Bilambil Residential Subdivision Modification 4

Conditions B24 and E7 regarding bushfire safety
State Significant Development Modification Assessment
(MP 05_0198 MOD 4)

August 2020

Subtitle: Assessment Report

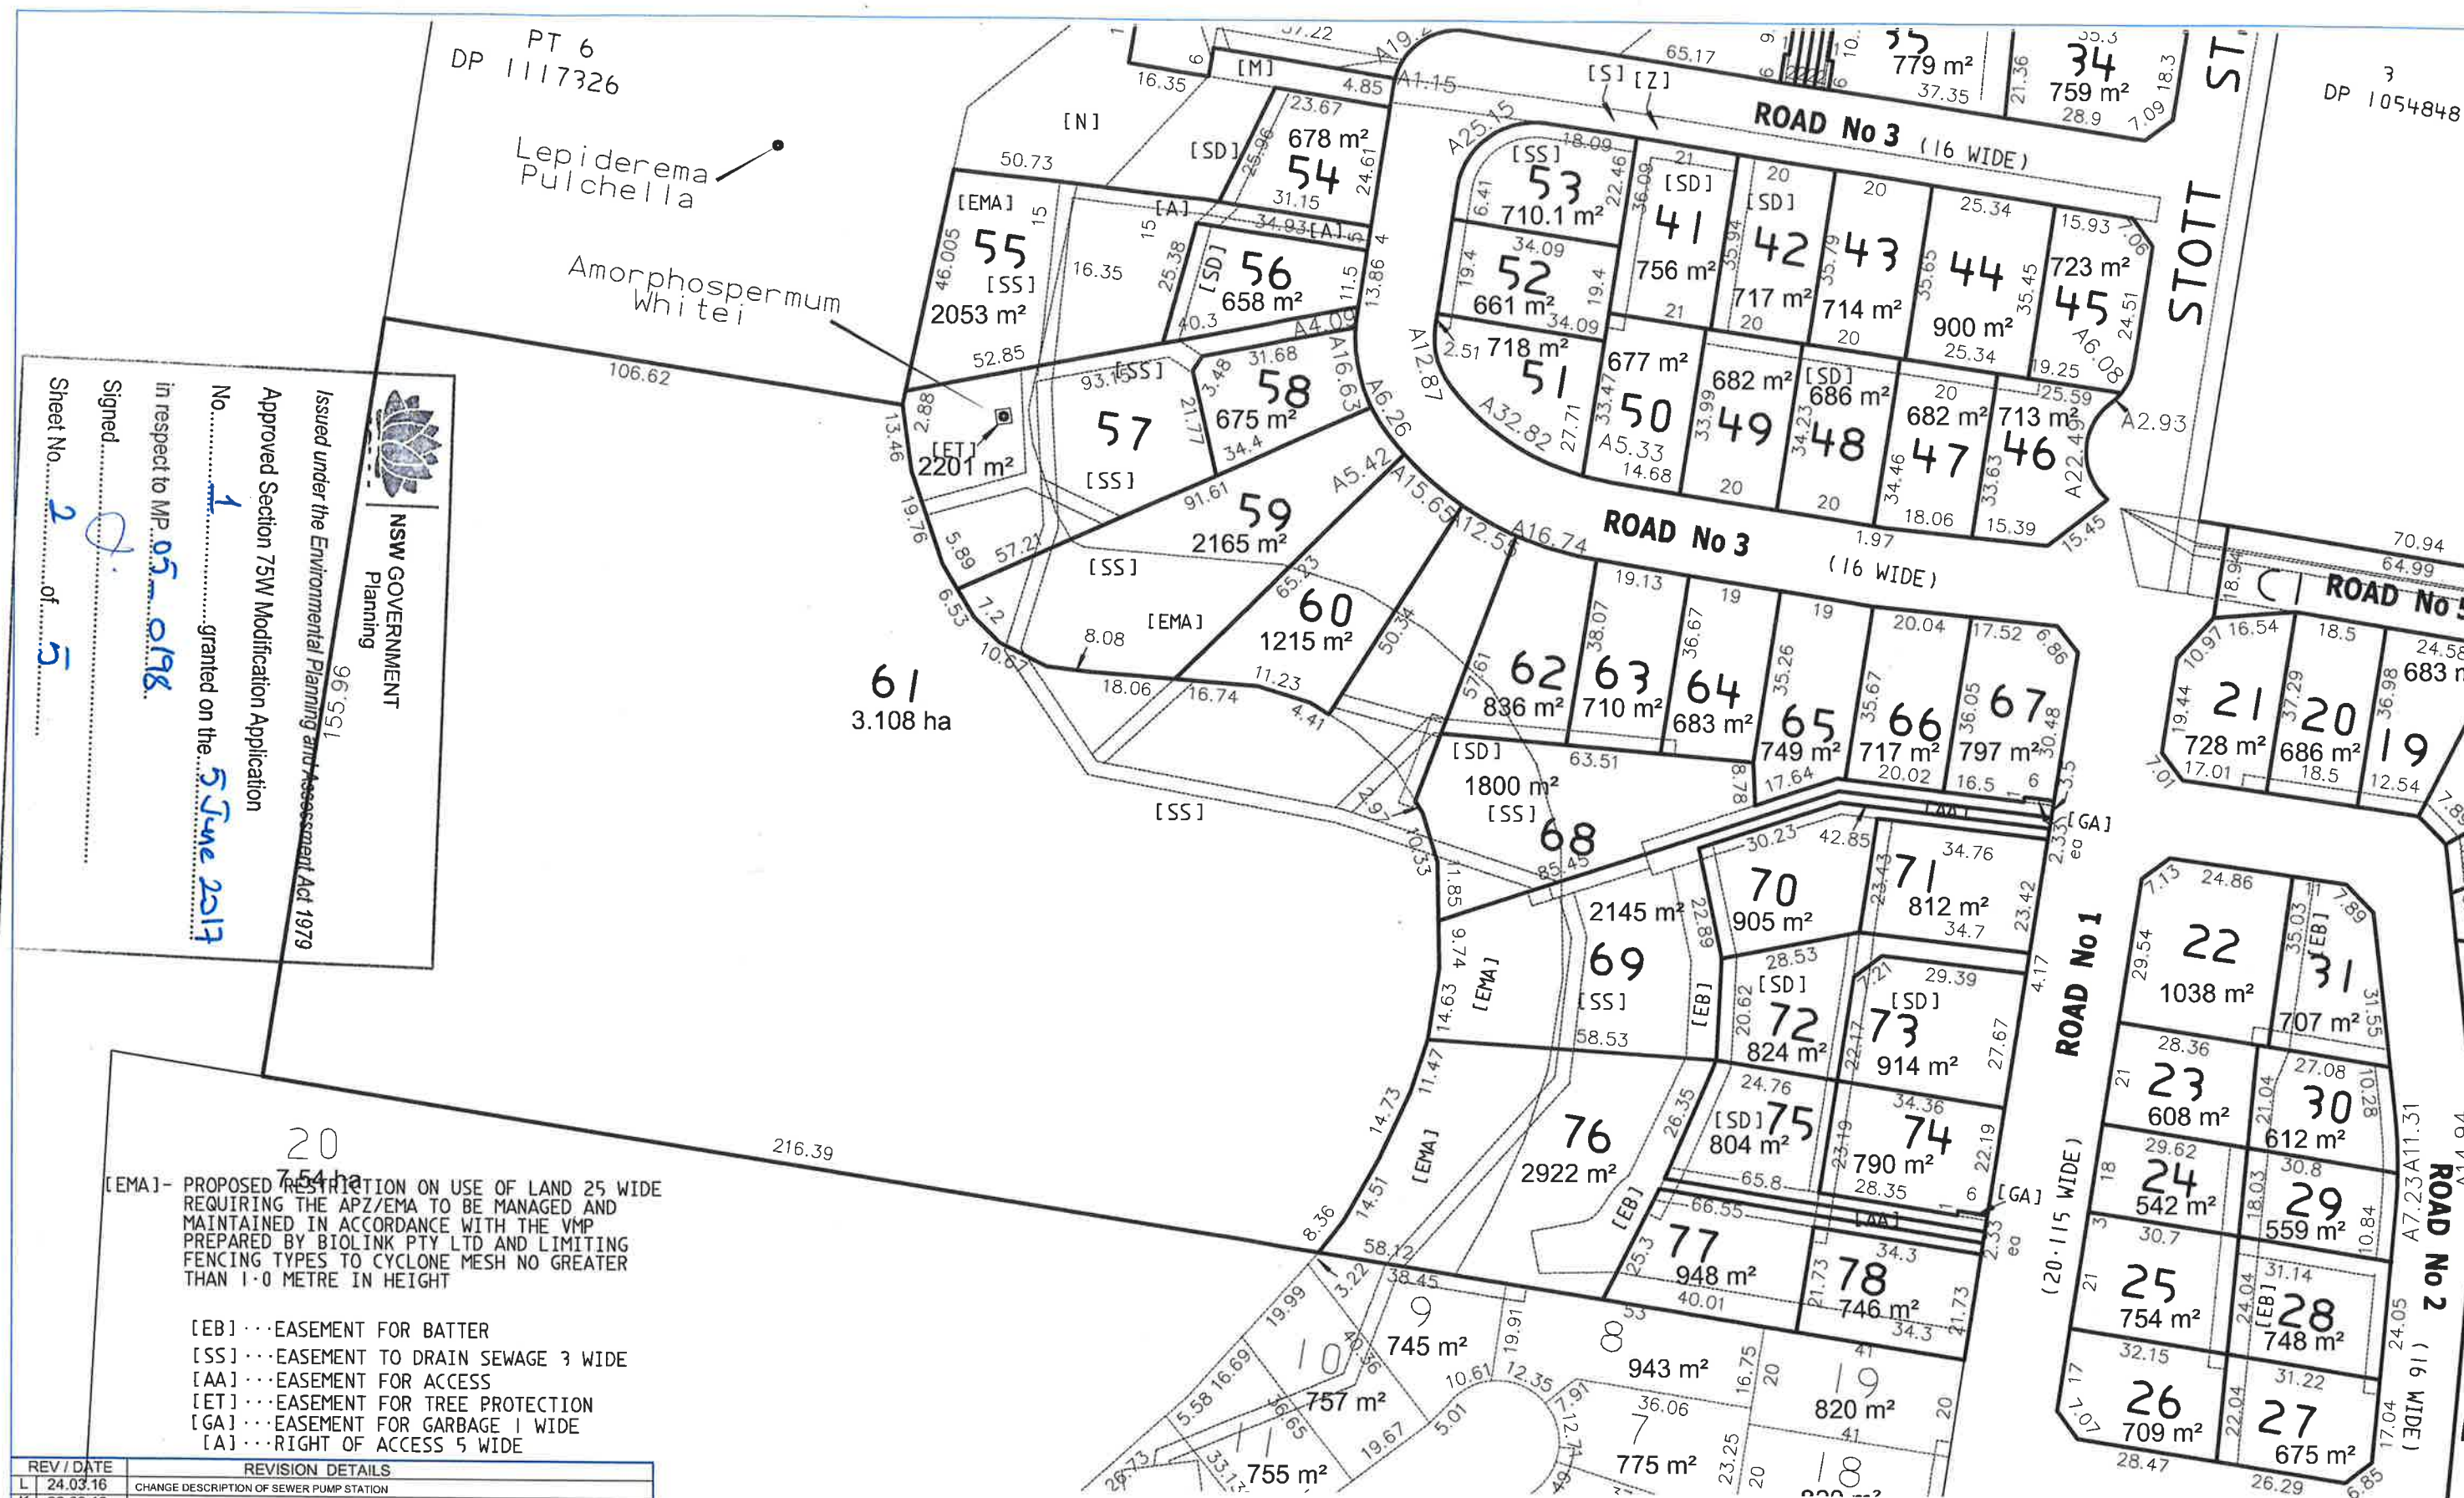
The changes to Lots 32 to 40 are proposed in response to Council's concerns that complying building envelopes cannot be accommodated within the previously approved smaller lots with APZ constraints. The approved and proposed subdivision plans are shown in **Figures 3 and 4**.

- lack of certainty for the long term protection of threatened flora species
- raised concerns that the required APZs and approved EMAs in future lots unlikely to leave sufficient space to accommodate a dwelling

In response, the Applicant's RtS provided an updated APZ Management Plan, which considers the requirements of an updated Vegetation Management Plan and Tree Removal Plan. An amended subdivision plan was also submitted showing an additional 5m buffer between the APZ and the indicative building envelopes on lots 38, 39 and 40.

- a subdivision plan that incorporated minor amendments to the configuration of Lots 32 to 40 to achieve compliant EMAs and APZs
- an updated APZ Bushfire Fuel Management Plan
- an amended Vegetation Management Plan
- an amended Tree Removal Plan.
